Council Reference: DA04/0064.11 LN11043  
Your Reference: DA 492-11-2003 MOD 6

**Development Application DA 492-11-2003 MOD 6 (Council reference DA04/0064.11) - amendment to Development Consent DA04/0064 for a mixed commercial/retail tourist accommodation (DA 492-11-2003 MOD 6) at Lot 4 Sec 4 DP 172565; Land has no related Property or Address; Lot 23 DP 1064172; No. 32 Marine Parade KINGSCLIFF**

WEST ELEVATION
SCALE 1:100

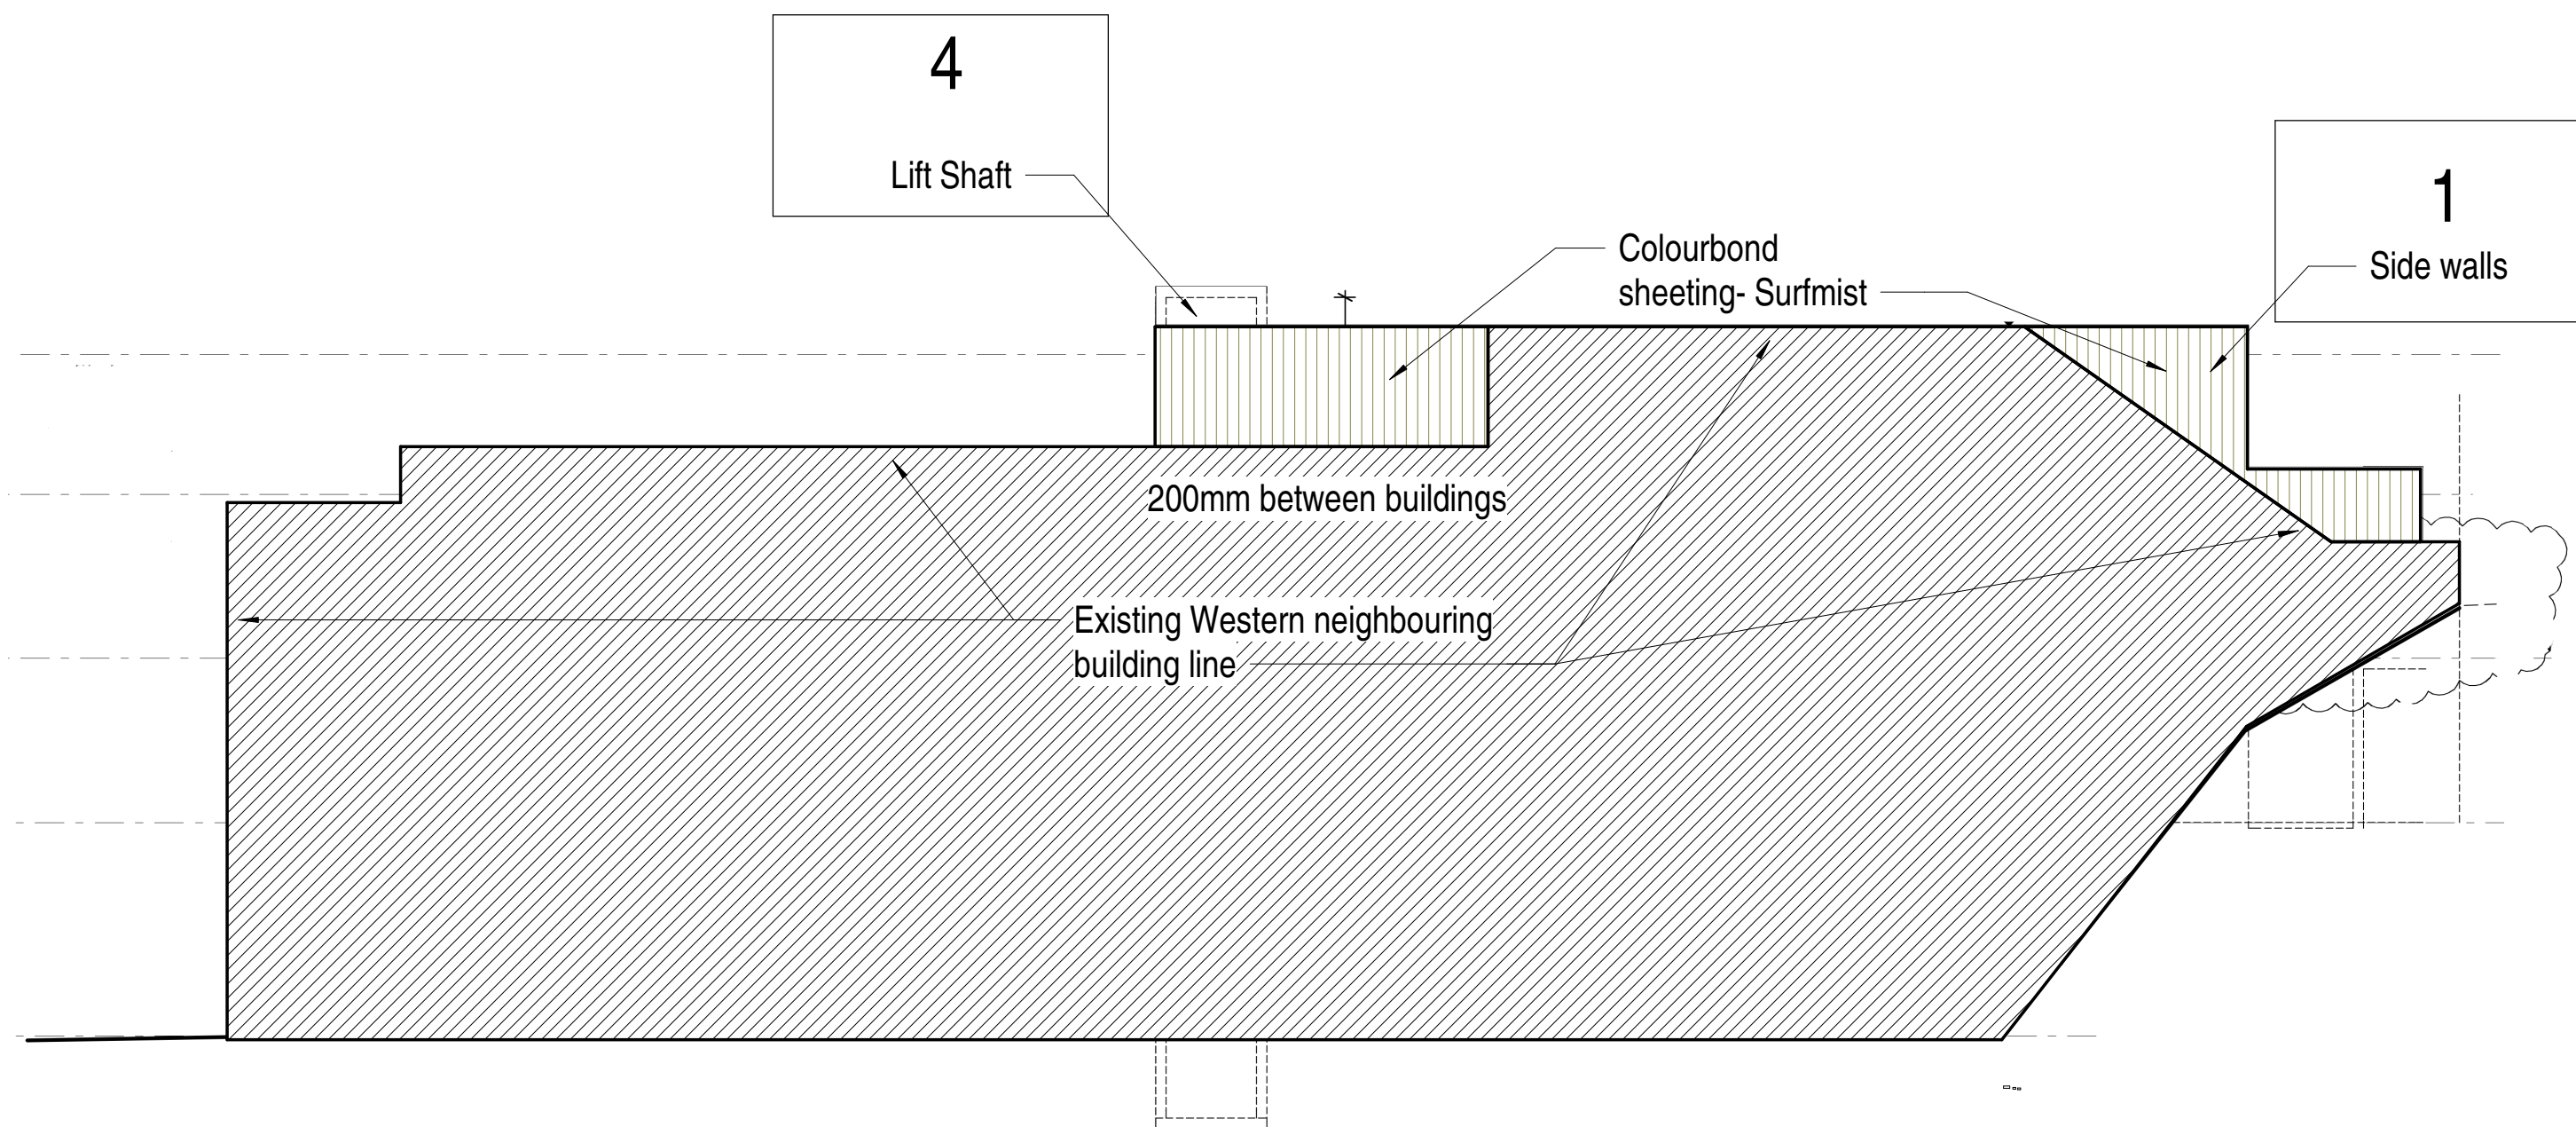
- Council notes that the proposed Inclusion of fire rated opaque glass bricks to the eastern external wall to the residential units to the first floor Unit 102 (media room) and third floor unit 301 (bed 1 & ensuite) will not affect the height; or have other detrimental impacts as highlighted in the original assessment or subsequent modification applications;

- The location of the opaque glass bricks is approximately 16 m along the eastern boundary. This puts the location of the proposed glass bricks approximately in between the carpark and the building adjacent. It is not considered that there will not be any effects on privacy.

- Council's Building Unit discussed the proposal with the applicant Nick Folkers from Evolve Planning Services. It is considered the fire rated glass blocks have already been installed in the south – eastern elevation on the first and second floors. Council's Building Unit raises no objection to the Section 4.55 application subject to a new condition being imposed requiring the lodgement of a building certificate for the works already undertaken without consent

- *Prior to the issue of any occupation certificate a Building Information Certificate in respect of the installation of fire rated glass blocks installed in the south – eastern elevation is to be obtained from Tweed Shire Council.*
